During the examination of this scheme the issue of losing tree screening to the National Grid substation at Bicker Fen has been raised.

The loss of the tree screening was indicated in the 'Change application' consulted on by Ecotricity in the summer of 2023. Boston Borough Council responded to this on 28 July 2023 and the text of our response was submitted at Deadline 1 (REP1-027). The issue of tree loss was also the subject of our accompanying comments at Deadline 1 that are also contained in REP1-027.

FIGURE 3.8 – Extent of Plantation clearance in Additional Works areas at Bicker Fen National Grid Substation

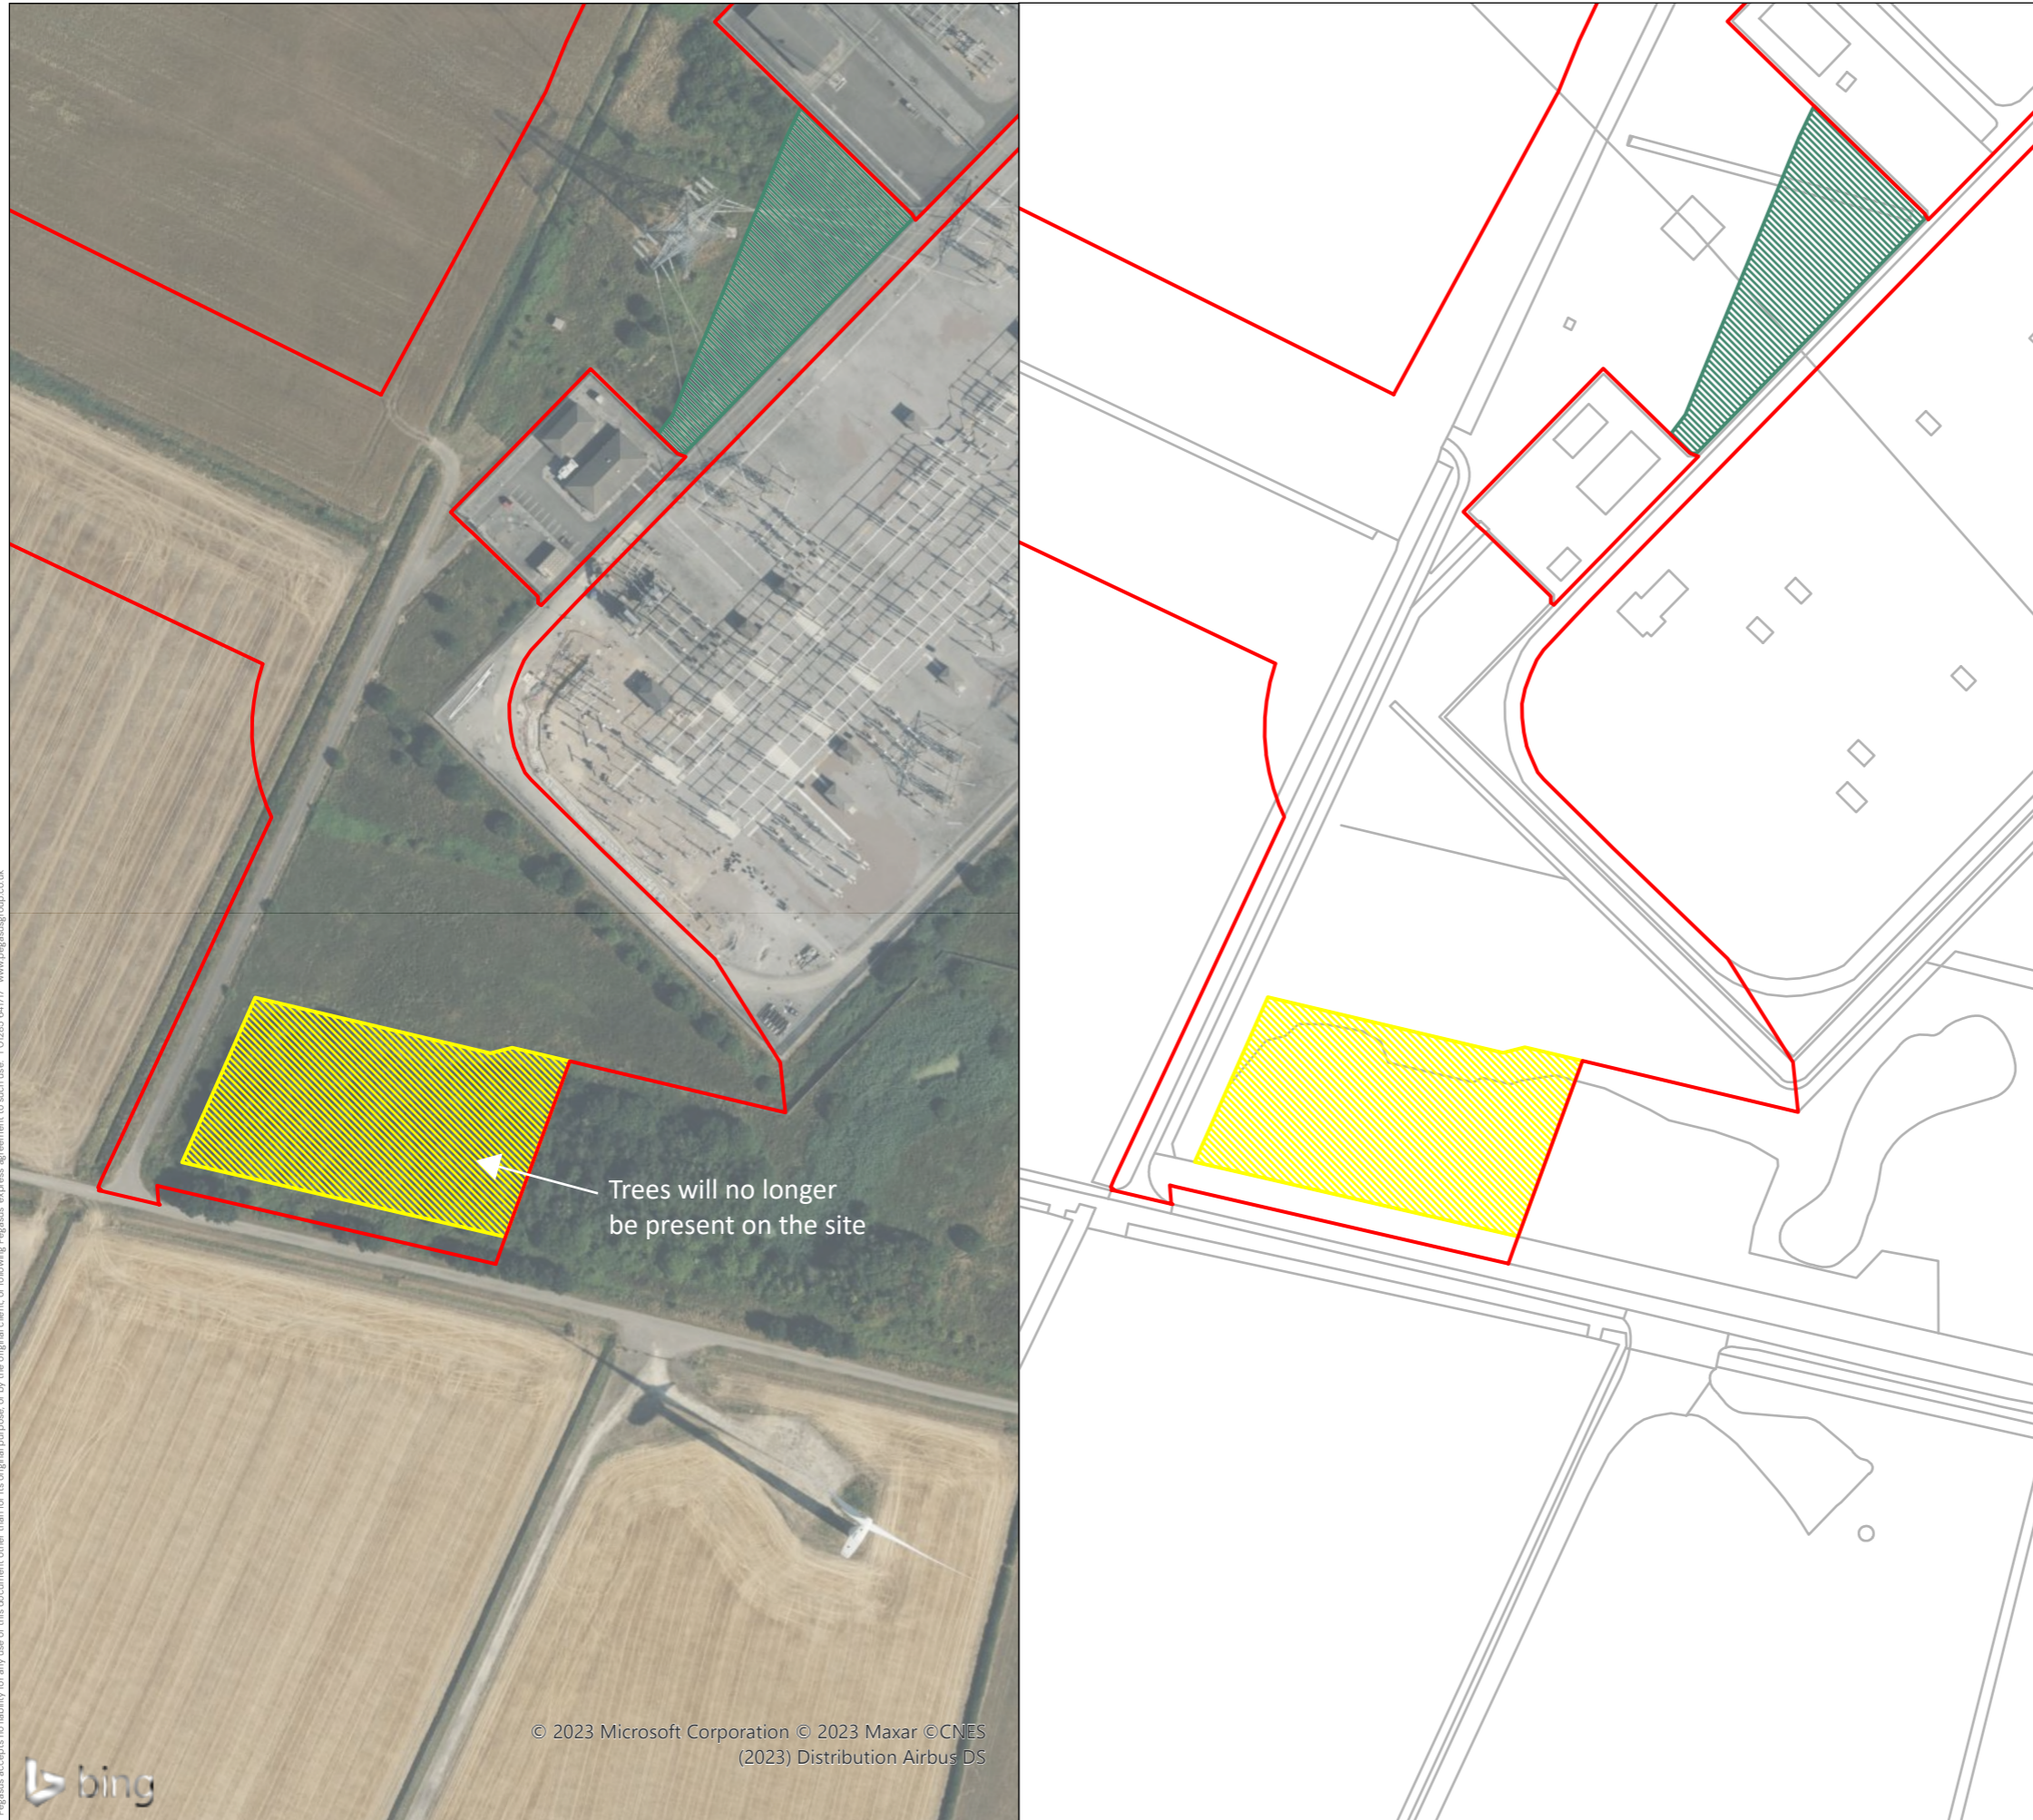
The Forestry Commission operate at a national scale and at that strategic level replacing the trees at the solar park site is a reasonable point of view. However, locally it does not address the level of tree cover in Boston Borough.

The applicants have continued to work on this issue and have drafted amended wording to be inserted into the Outline Landscape and Environmental Management Plan:

1. *In addition to the offset planting to the north-west of the Energy Park Site, the following mitigation and/or enhancement measures would be undertaken:*

- 1.1. *The Applicant will offer landowners hosting the grid connection cable in Boston Borough hedgerow planting, gapping up of existing hedgerows, or another improvement to connectivity for biodiversity between natural habitats as may be deemed suitable on their landholding. This will be at no cost to the landowner(s) and the cost of the planting or other measures (inclusive of contractors, legal agreement, plants and maintenance) will be to a maximum value of £10,000.*

- 1.2. *If landowner agreement cannot be secured, the Applicant and/or its appointed contractors will:*
 - 1.2.1. *where possible, provide an alternative scheme for connectivity or planting in Boston Borough Council up to the cost of £10,000; or*

- 1.2.2. *provide a contribution of £10,000 to Boston Borough Council for connectivity or planting in Boston Borough Council.*

- 1.3. *The amount referred to in paragraph 1.2.1 and 1.2.2 is to be reduced by a proportionate amount based on the cost of any agreements reached with the landowners for hedgerow planting, connectivity, and/or biodiversity improvements under paragraph 1.1.*

- 1.4. *In the final LEMP submitted for approval under Requirement 8 the Applicant will confirm which of the measures detailed above (in paragraphs 1.1, 1.2.1, 1.2.2 or a combination of the measures) it proposes to implement.*

The Borough Council are happy with this approach.
